Consultation Response from KC, Conservation & Design

2024/90647 and 2024/90648 - Hunter House Farm, Wood Nook Lane, Honley, Holmfirth, HD9 4DU

Date Responded: 04.04.2024

Hunter House Farm Ground Floor Plan (part) 1: 50

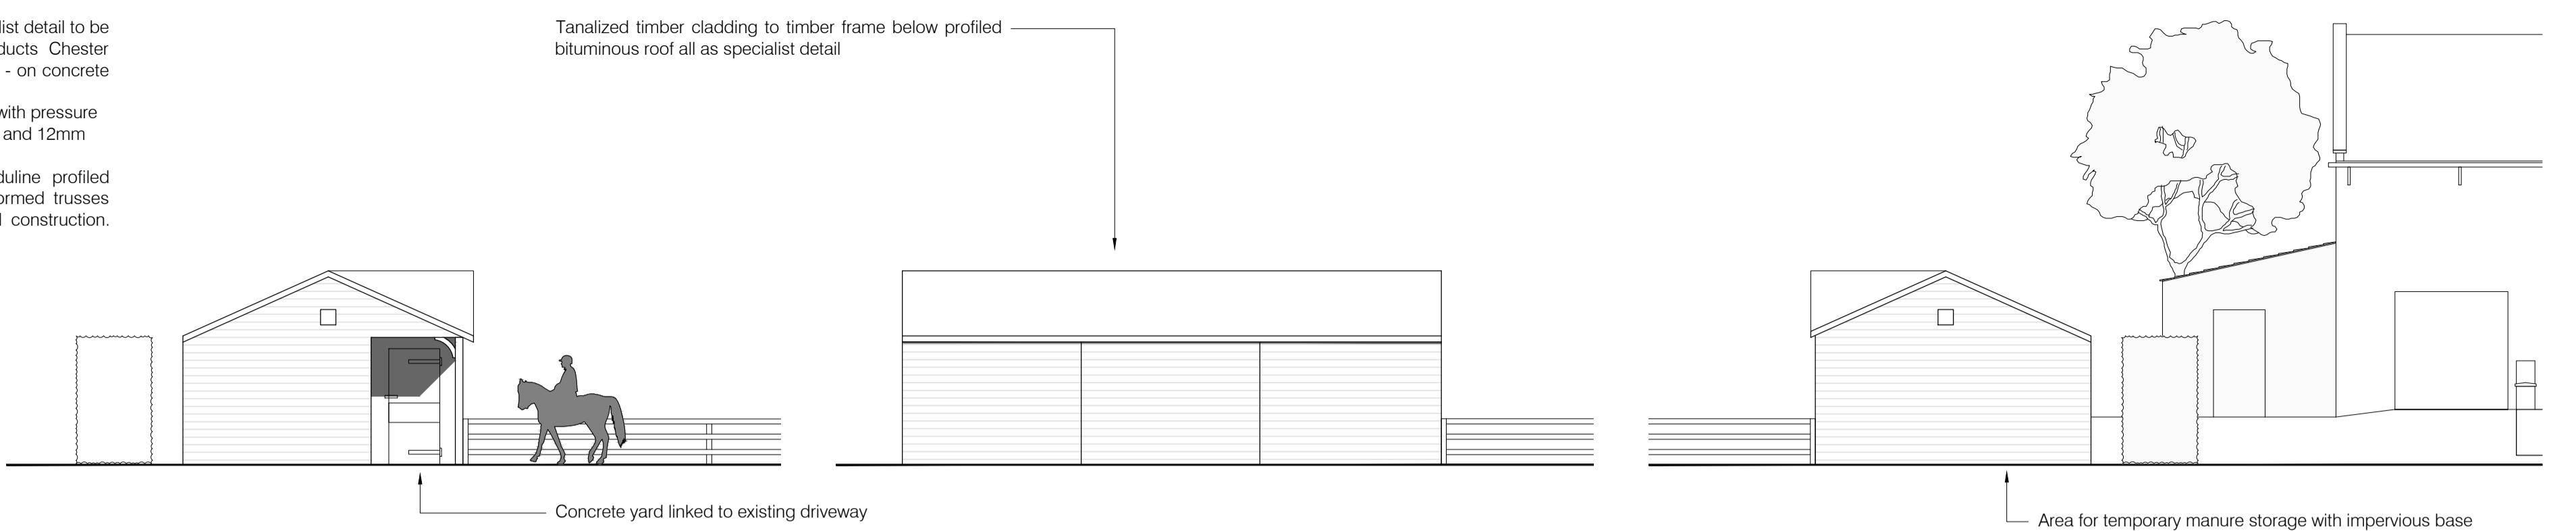
In terms of the works of the building itself, we are generally supportive of the proposals. However, we do have some concerns with the treatment of the historic floor and the internal walls of the building. The plans and supporting statement indicate that the historic flooring will be lifted and reused. We accept that the floor is not level, however, they could be lifted and re-laid. The setts and flags do form a part of the character of the building. We would equally not support the floor level being reinstated using concrete and the floor level should be formed using limecrete.

In regards to the internal walls, the plans seem to indicate that the walls will be dry-lined. The existing walls retain their historic limewash, which is appropriate from a technical and aesthetic perspective. We consider that the internal walls should be conditioned to be finished in limewash, or we could agree to plaster, but for the plaster to be lime plaster only. We do not support the current approach of dry lining the walls and this needs to be amended.

We are not convinced by the details of the proposed bi-folding doors to the existing opening. It is positive that the existing opening is to be retained, however, the proposed door detail jars with the character of the building. We consider that central opening doors would be more appropriate. We would ask for joinery drawings of the proposed doors.

To the front of the conversion, the plans show a small seating area being created which will have a glazed balustrade fronting it. We would raise no concerns with the formation of the seating area, however, we do not support the proposed glazed balustrade, which would appear incongruous and does not reflect or enhance the character of the building. We consider that the balustrade should be omitted from the plans.

The plans indicate that the existing coal store is to be demolished. We can find no evidence or justification for this loss. Further detail is needed to support this loss.

Stable Northern Elevation 1: 100

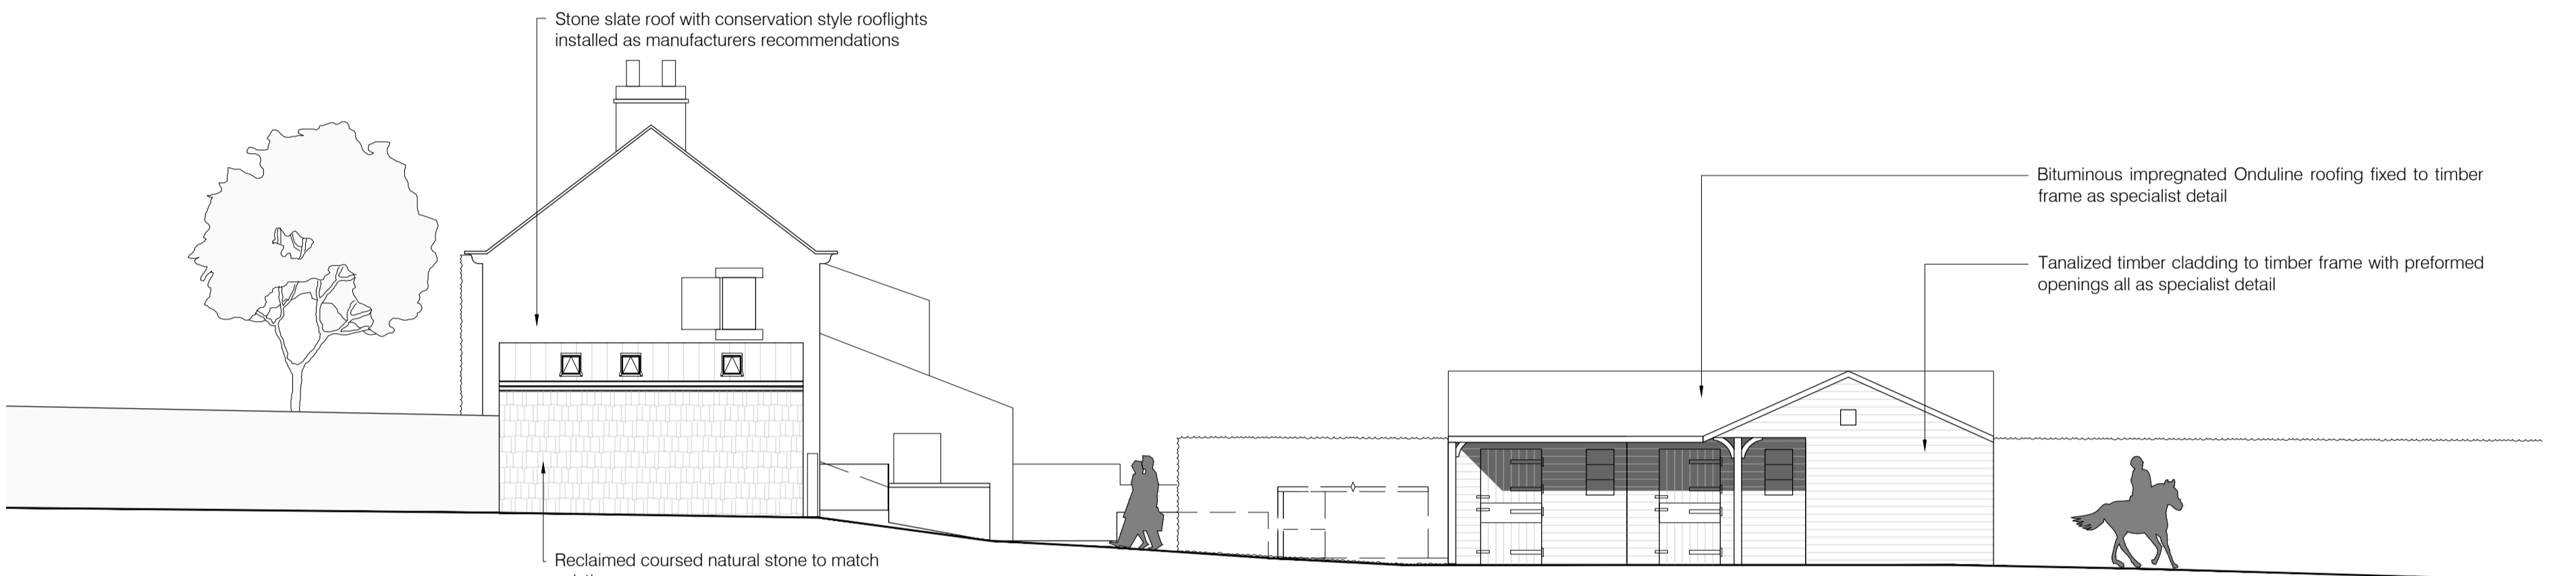
The final element of the proposals to be considered is the erection of the detached stables. The proposed location is to the immediate north, north east of the Farmhouse. We agree in part that the existing hedge will provide some form of visual mitigation of views from the north, however, there will be clear open views when looking from the west, south west. While appreciating the detached stables is to replace the loss of the former lean-to stables, we currently have concerns regarding the impact on the setting of the Farmhouse. The proposed stable building is of a reasonable size, being 4.7 metre longer and 2 metres wider than the proposed lean-to extension and will create a visually strong feature in the setting of the farmhouse. Having reviewed images of examples of such stable buildings, it has become more evident how visually intrusive the building would be.

We appreciate the reason behind the proposed detached building however, we are not convinced by the proposals and do consider that it would have a harmful impact on the setting of the listed building. It may be that with a small building and further consideration of its position, the concerns could be overcome, however, as stated in its current form we are unable to support the proposed detached stable building.
